Fosse Green Energy
Development Consent Order 202[]

8.14 Statement of Common Ground with Phillips 66 Limited

Regulation Reference:	Regulation 8(1)(e)
Planning Inspectorate Scheme Reference:	EN010154
Document Reference:	EN010154/EXAM/8.14
Author:	Fosse Green Energy Limited

FIGURE TITLE
400KV PIPELINE CROSSING
FIGURE NUMBER
Figure 1-1
REV.
01

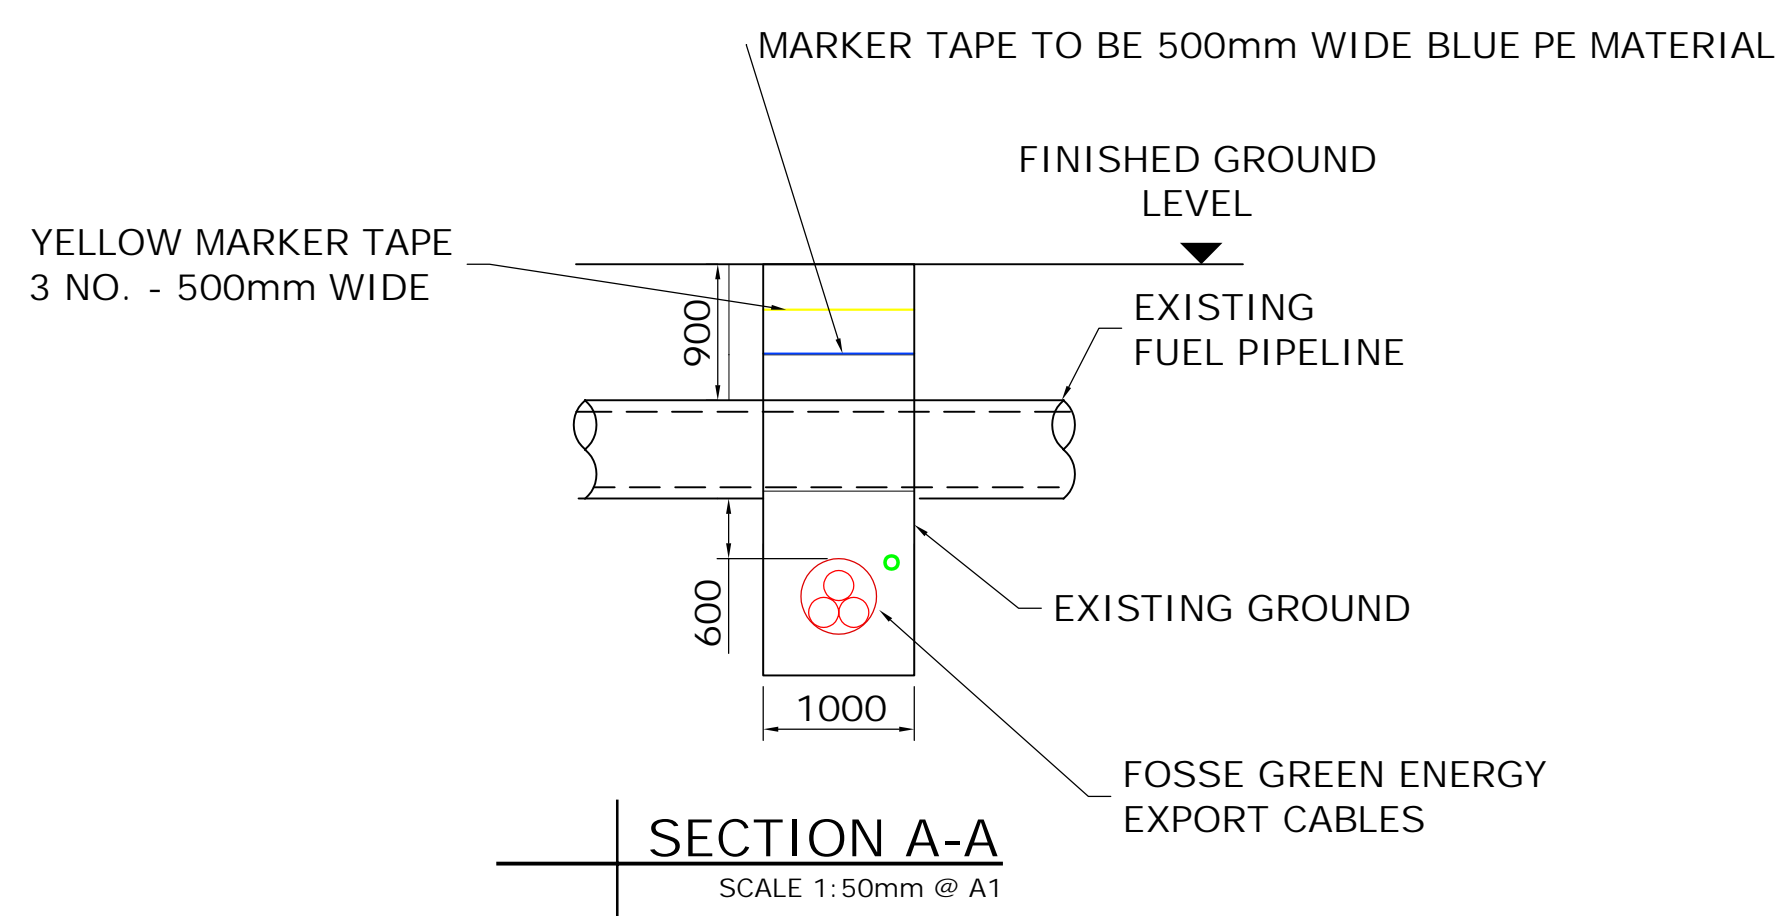
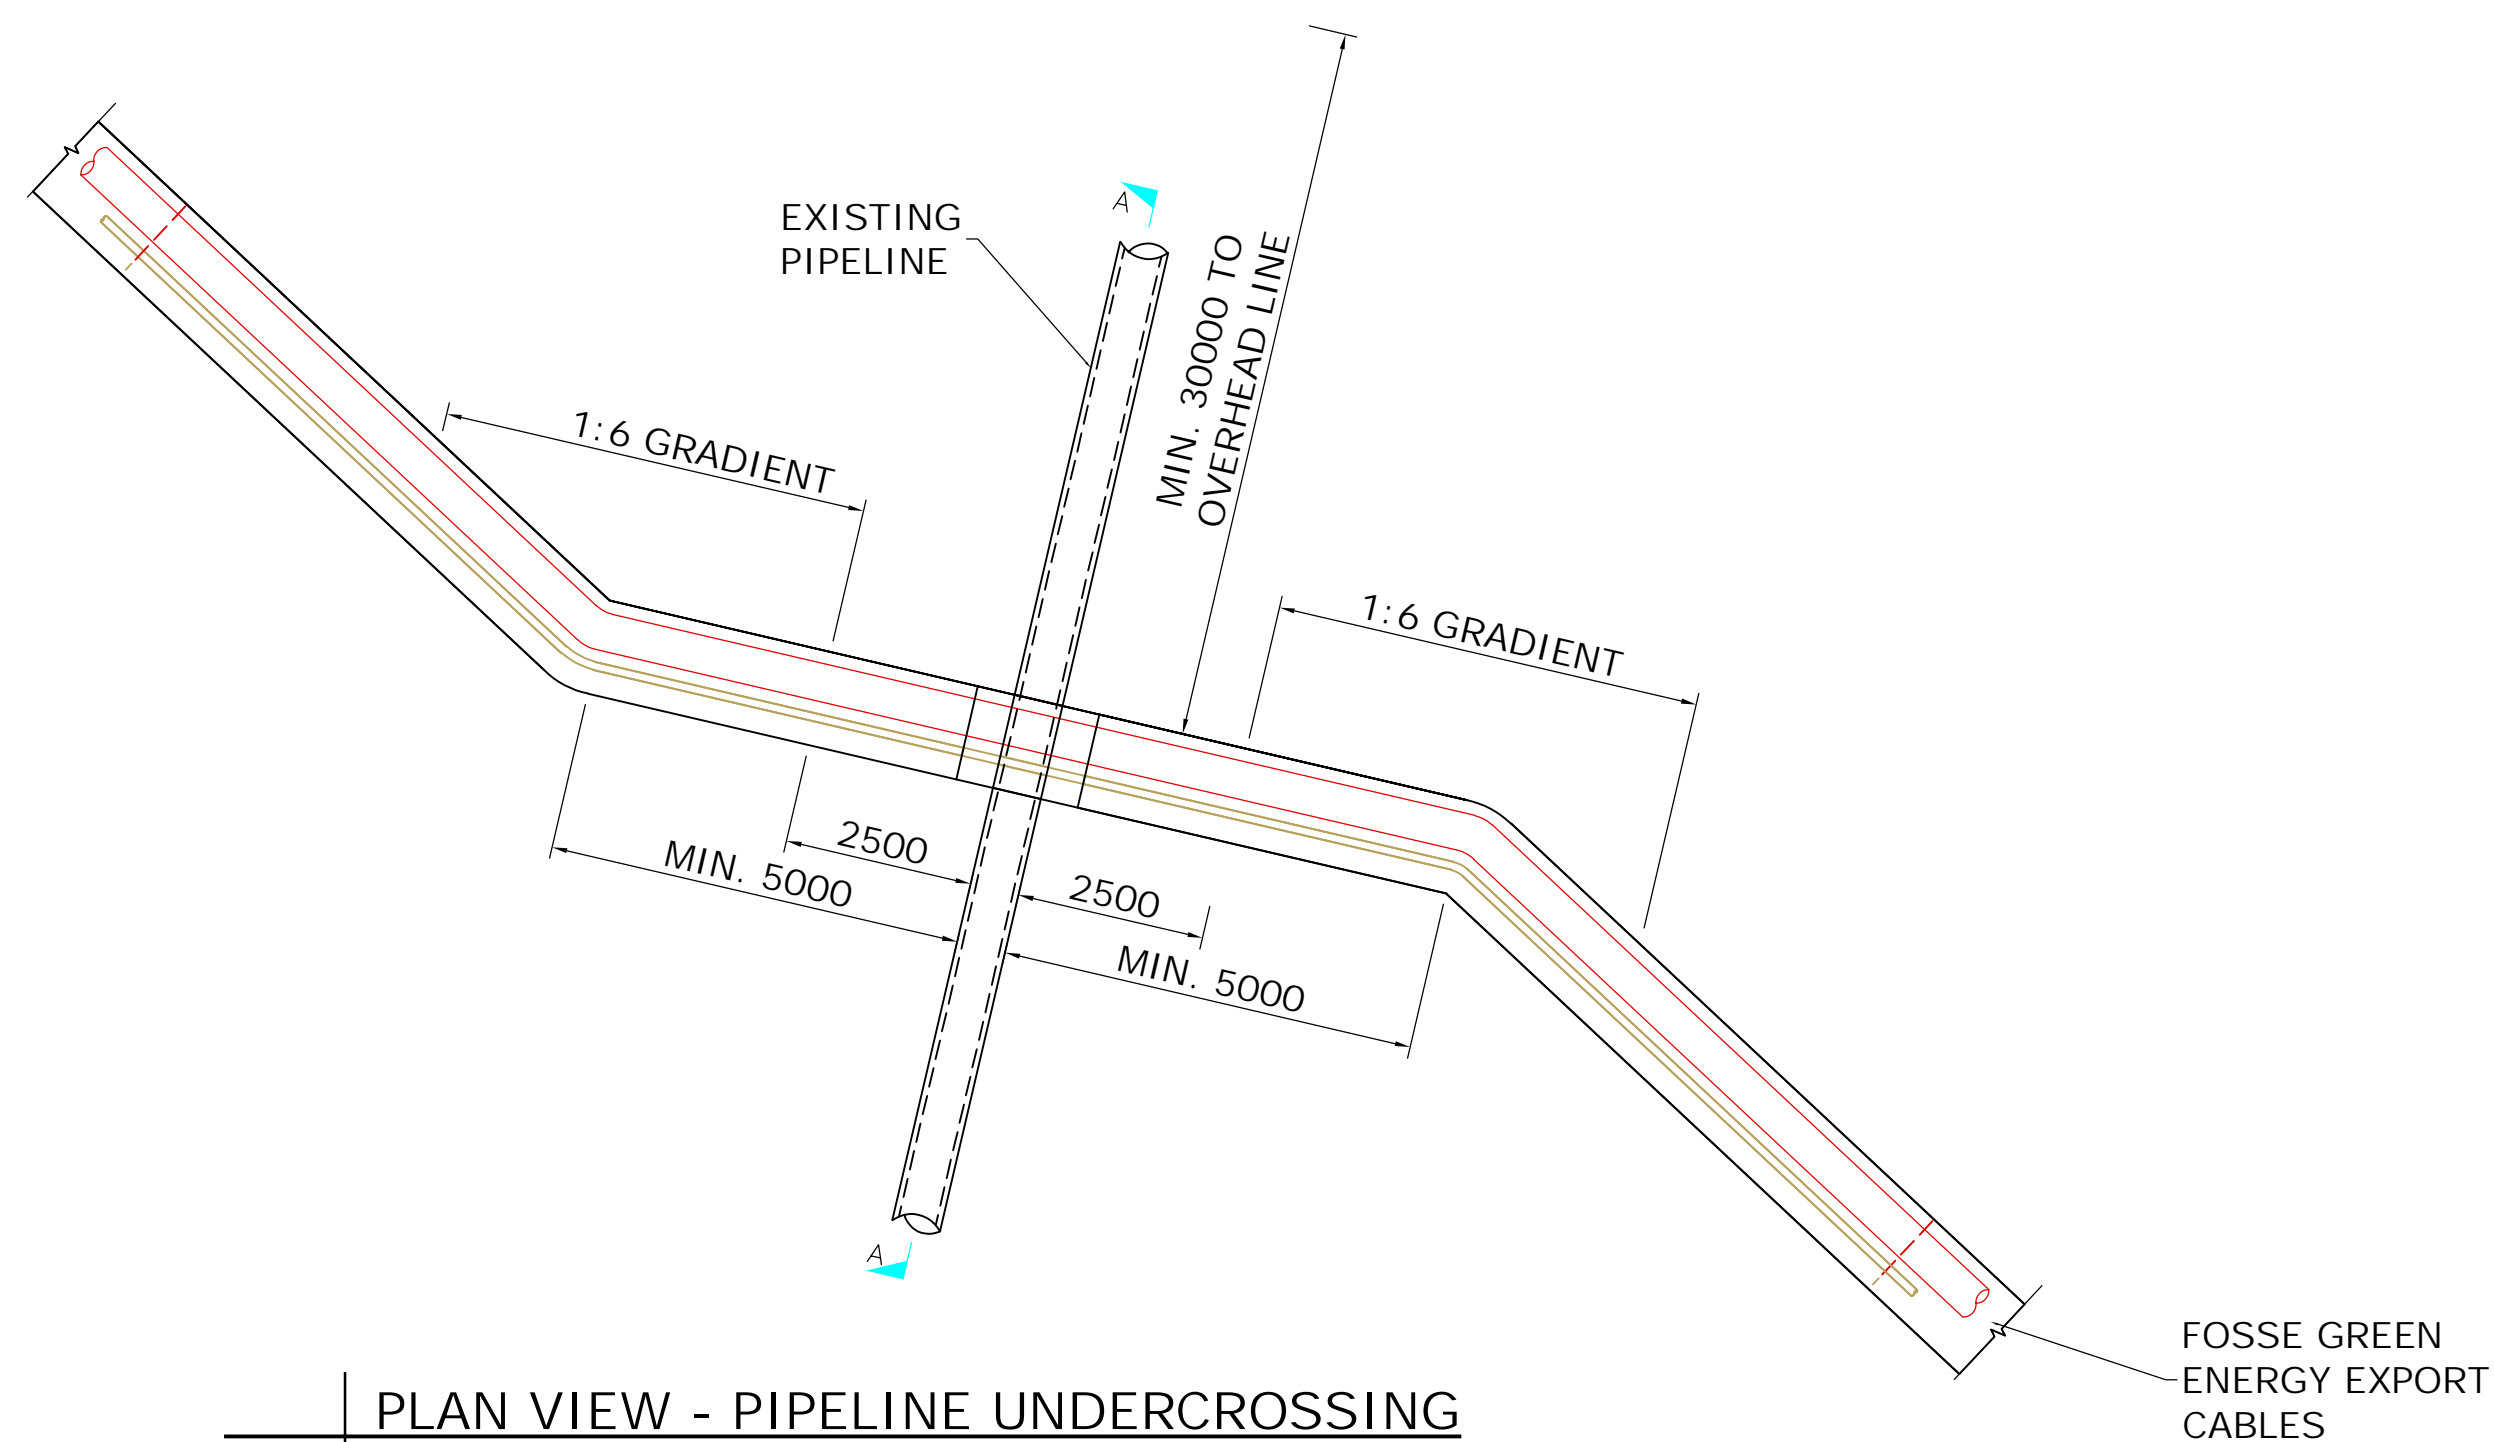
Reference	Description of Matter	P66 Position	Applicant Position	Status
		further investigations have been carried out.	<p>The all-party call in November 2025 focussed on FF and BPAs concerns and resulted in the Applicant agreeing to carry out an AC interference modelling study (the Risk Assessment).</p> <p>The Applicant is in discussion with FF regarding bespoke protective provisions to be included in the draft DCO [APP-016] and has undertaken and provided an AC Interference Modelling Study (or Risk Assessment) which assessed the risk to the pipeline from the Cable Corridor. These PPs will ensure that Prax maintain the necessary rights to allow continued operation and maintenance of its pipeline. The Applicant's position is identified at matter 3.1.2. The Applicant considers it very unlikely that mitigation works would be required in the area and has committed to crossing the pipeline at 90 degrees to reduce impacts.</p>

Reference	Description of Matter	P66 Position	Applicant Position	Status
4.2.1	Pipeline crossing	<ul style="list-style-type: none"> P66's concerns in relation to safety and security of national fuel supply have been outlined in detail in its written and oral submissions. The Crossing Details are approved in principle (subject to final approval by P66) and subject to including this as the "outline specification" within a set of protective provisions (in a form either (a) as agreed between the parties or (b) in the form submitted by Fieldfisher on behalf of BPA/Prax (now P66) at Deadline 5. 	<p>The Applicant's position with regard to the AC Interference Modelling Study (or Risk Assessment) is identified at matter 3.1.2.</p> <p>Further information on the proposed works, offset distances, and crossing angle are provided in the updated AC interference modelling report and engagement is continuing with P66 to secure appropriate protective provisions which reflect this.</p>	Under discussion
